Article 21 of the Town and Country Planning (General Development Procedure) Order 1995
Application for approval of details reserved by condition 6 of previously approved planning
application R/44/12/
19 Manor Road Rustington,,

Condition Number 6

Arun District Council have decided to **REFUSE** details reserved by condition for the **following reasons:**

1118/40/C

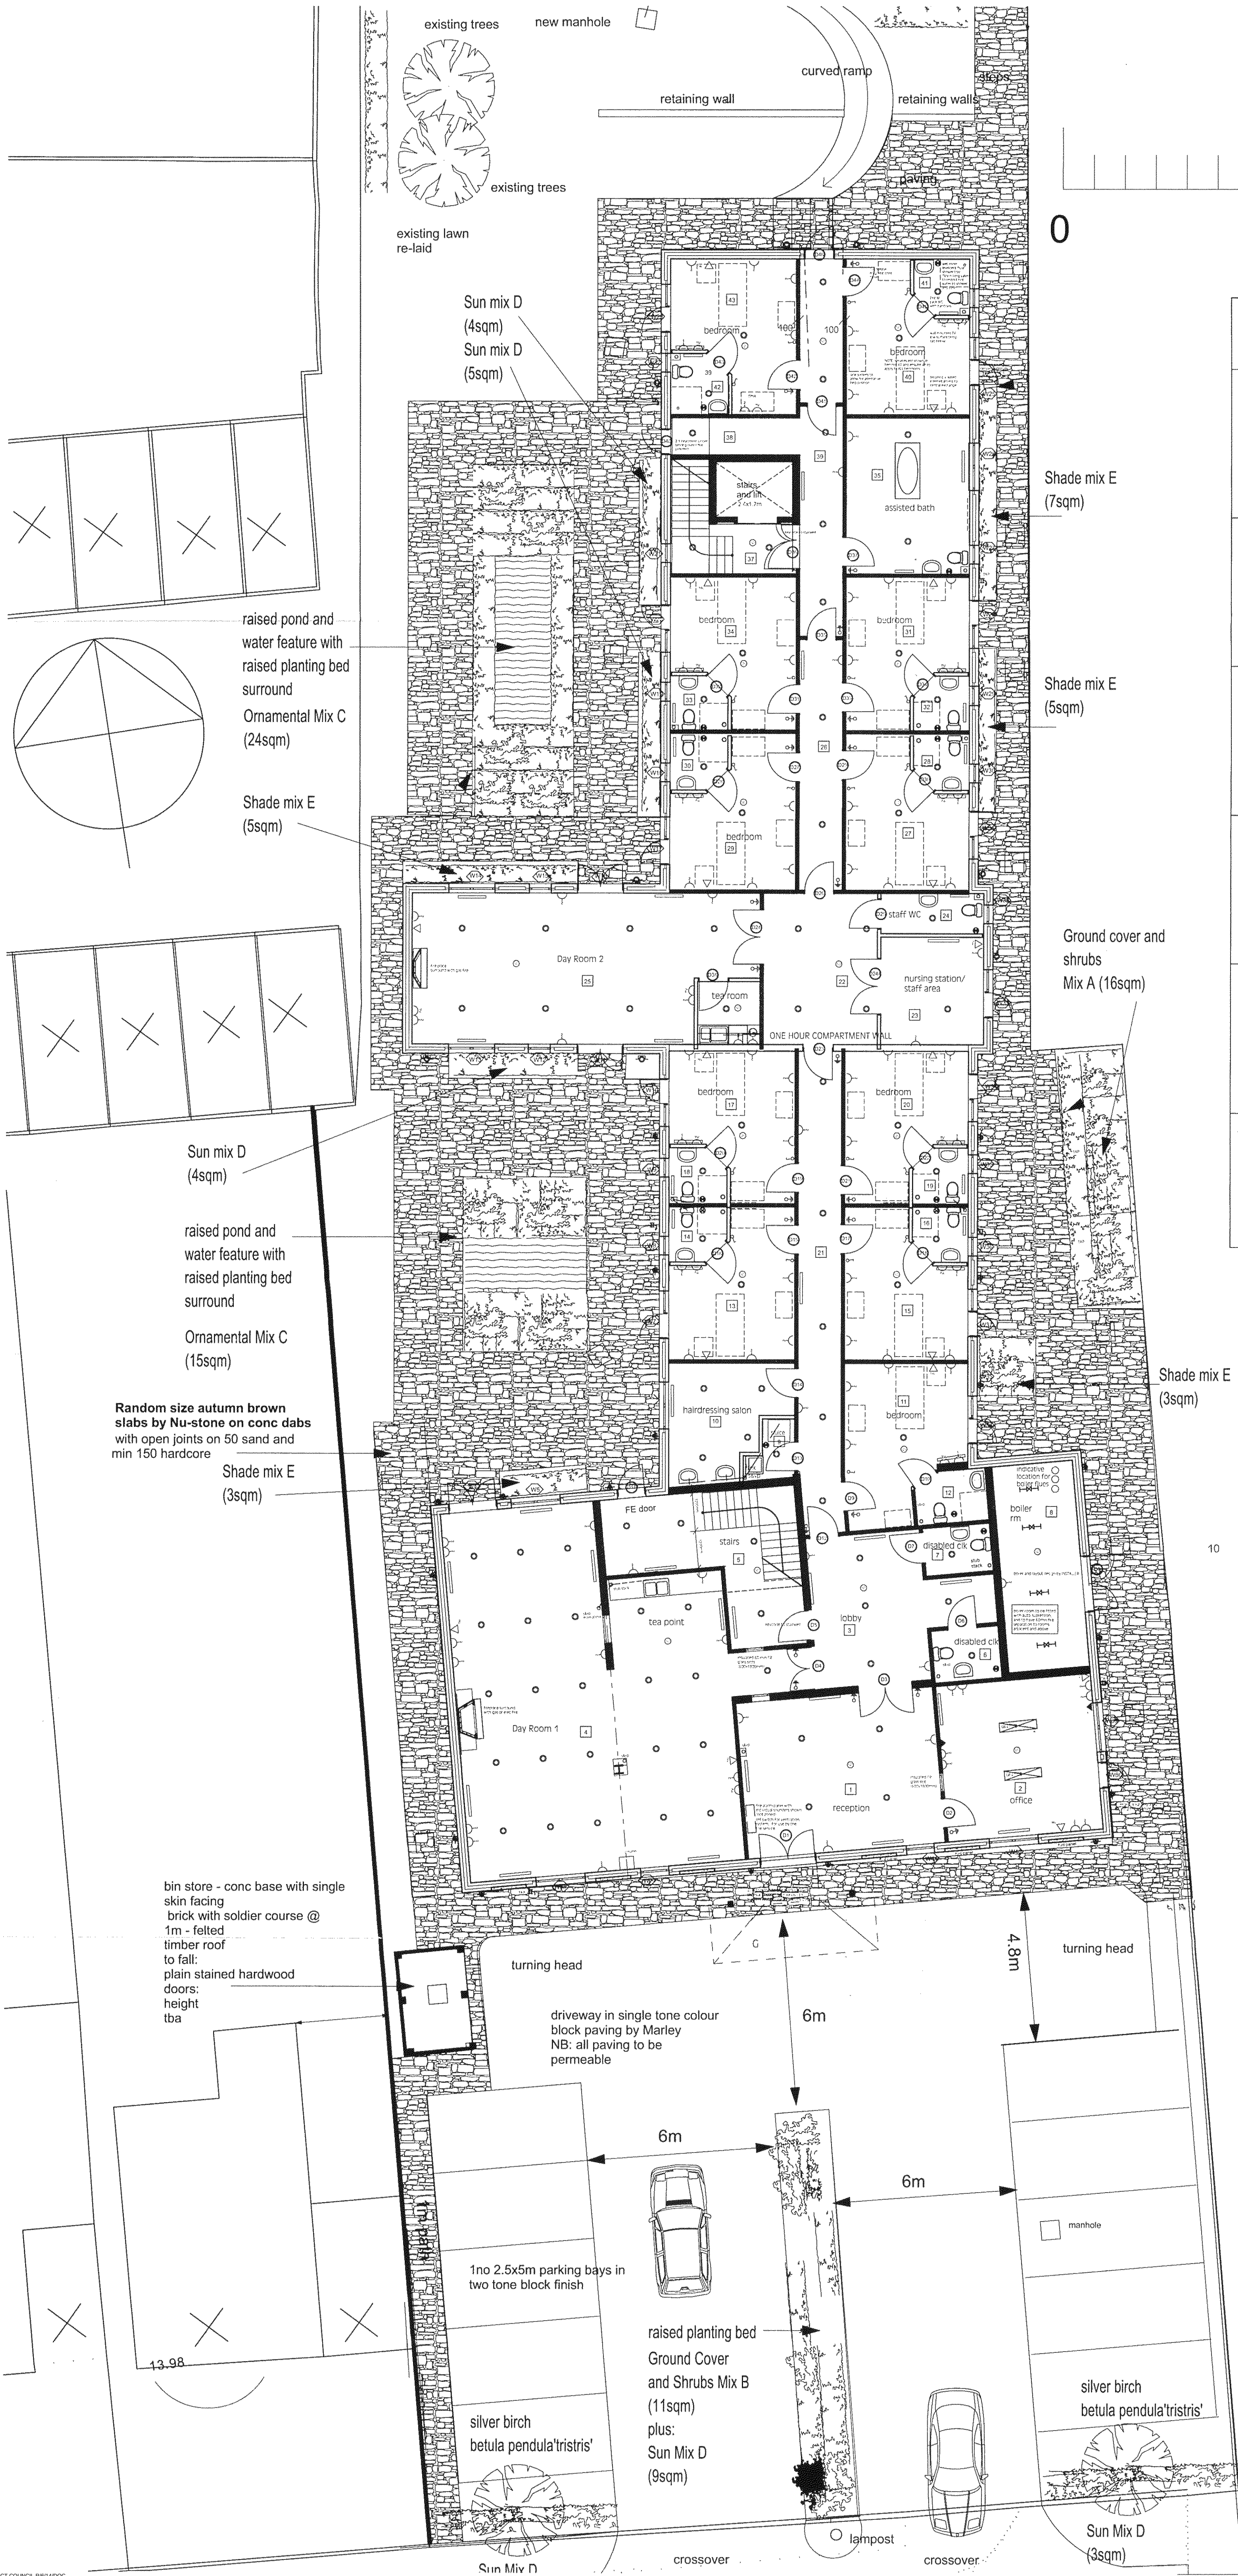
This condition cannot be discharged since the number of trees suggested on drawing no. 1118/40/C is insufficient. 4 trees were indicated in the front parking area on the approved ground floor plan on R/44/12 and this changed to 2 on the western boundary and 3 on the site frontage on the refused details submitted under R/89/13/DOC. This proposal has reduced the number to just 2 on the frontage.
